April 4, 2023  
File No. 19-062.200

**Subject: Geotechnical Plan Review, Report Addendum, Comment Response  
Proposed SFR, East Lot, Parcel 302405-9151  
6423 E Mercer Way, Mercer Island, WA**

**APN: 302405-9151
 COVER SHEET
 ALTMAN PARCEL B
 MERCER ISLAND, WASHINGTON**

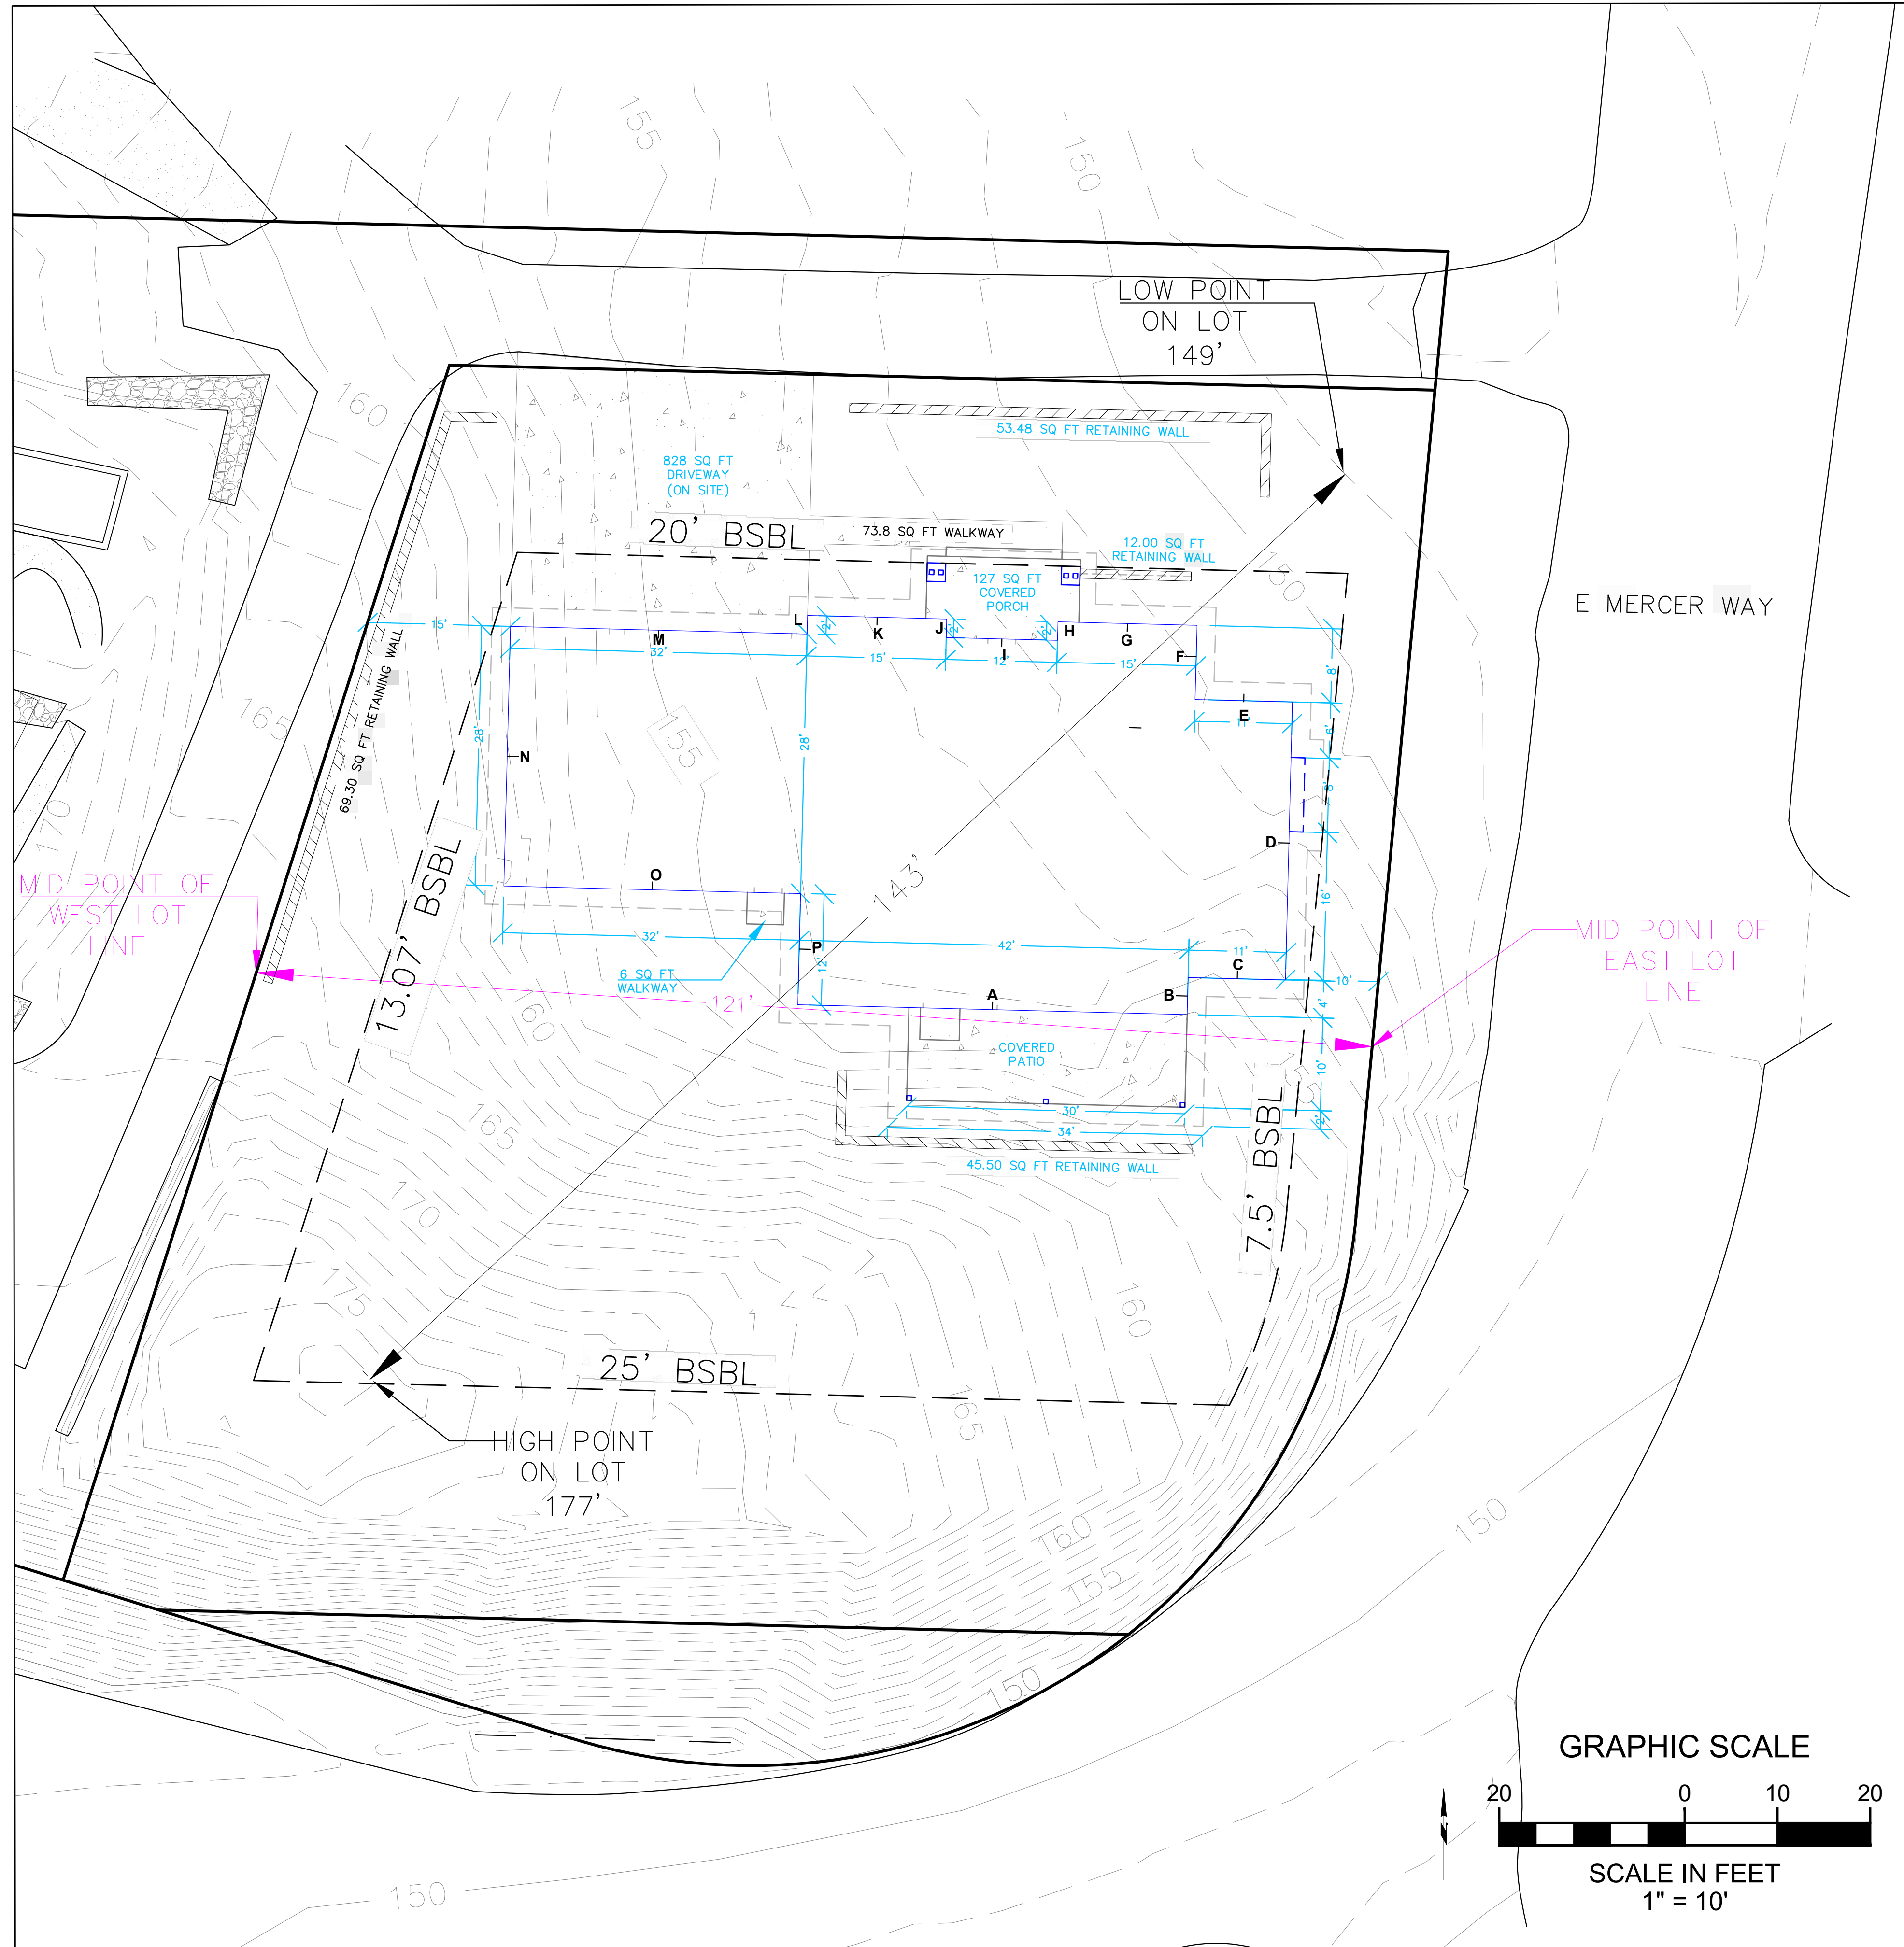
- **Update** - Update all plans and calculations to comply with 2018 IBC.
- **Plan Review and Minimum Risk Statement** – Reviews are to be conducted on the final plans and will be conducted at the appropriate time.

Sheet Number
S2.0
3 of 10

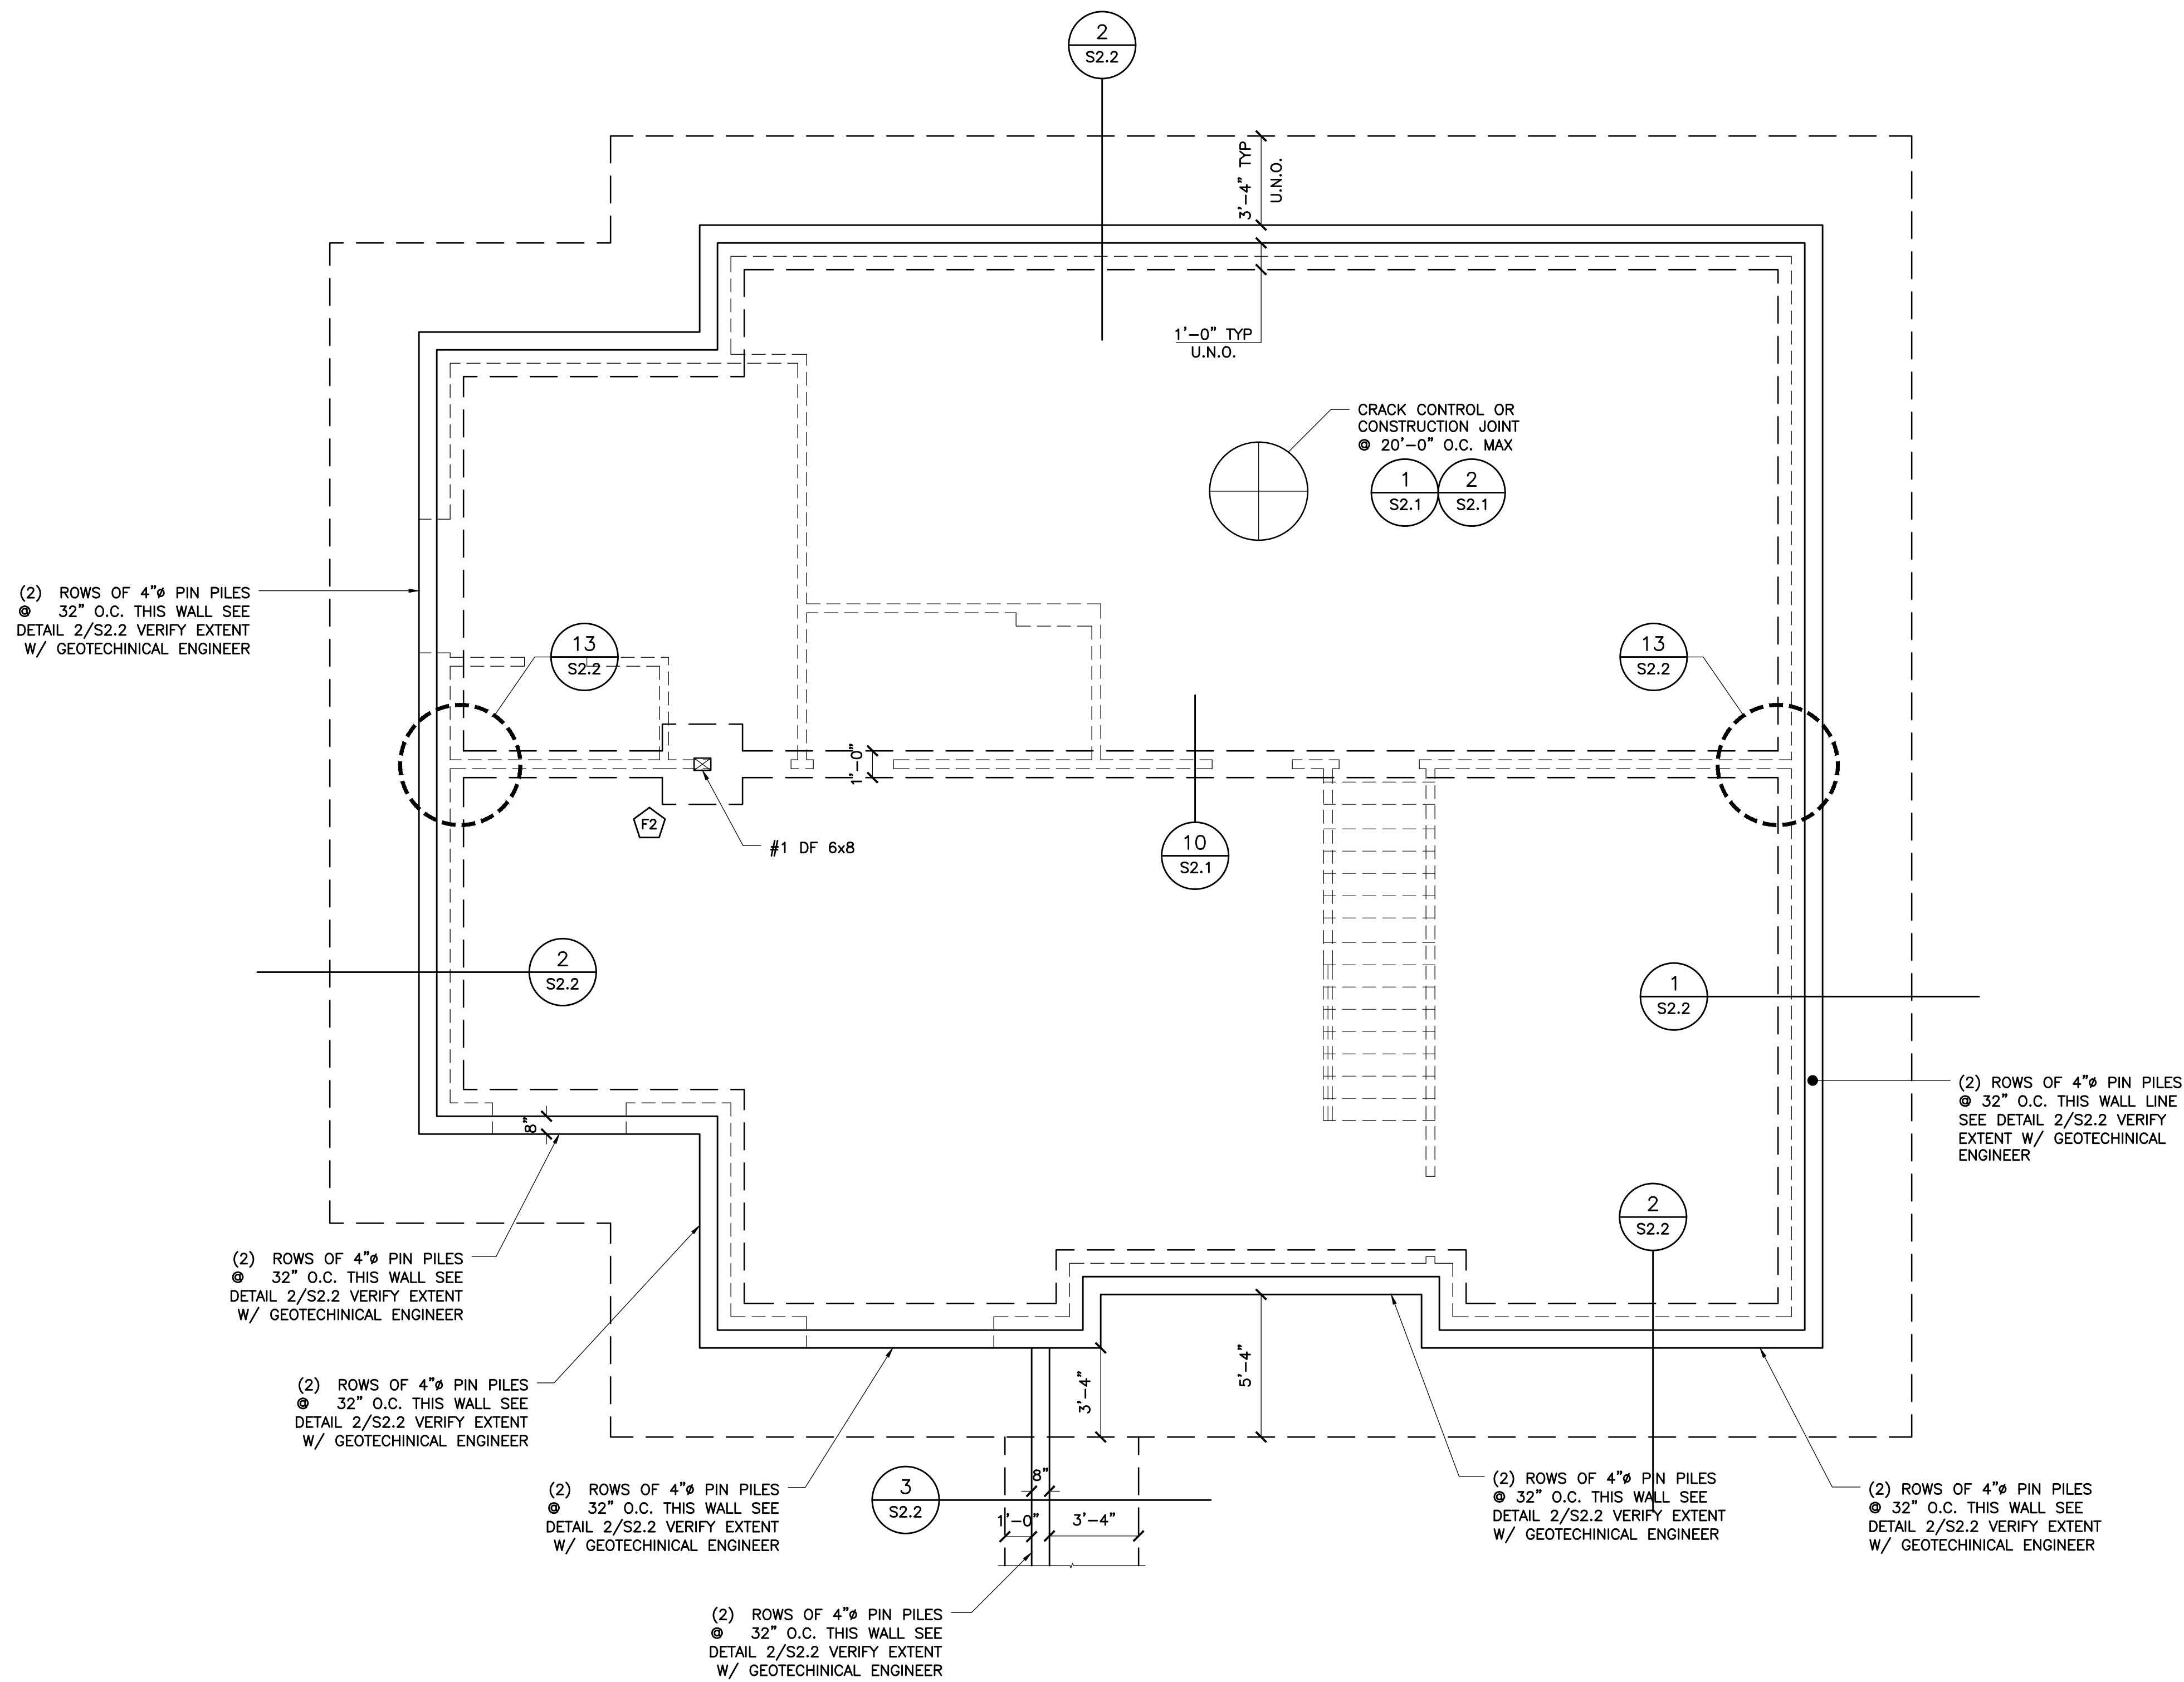
- **Pin Piles** – Per our Report Addendum dated December 3, 2021, spread footings may be used for foundation support. Per the foundation plan call-out (Sheet 2.0), portions of the foundations are to be supported on two rows of 4-inch pin piles on 32-inch centers. Recommendations for pin piles are provided in our April 16 report. 4-inch pin piles are typically driven with a small excavator mounted hammer and jack hammers are not appropriate for this size pile. See the table on page 10 of our April 16 report for refusal criteria. One minute of driving for one inch penetration is the criteria for a 2-inch pin pile and is not appropriate for a 4-inch pin pile. Welded splices are not appropriate for pin piles, which should be spliced using fitted compression sleeve couplers, per our report. Load testing should be done on 3 percent of the installed piles or a minimum of 1 pile, per ASTM 1143/D1143M – 07. The suggestion that the parameters given on the plan sheet are derived from our April 16 report is incorrect.
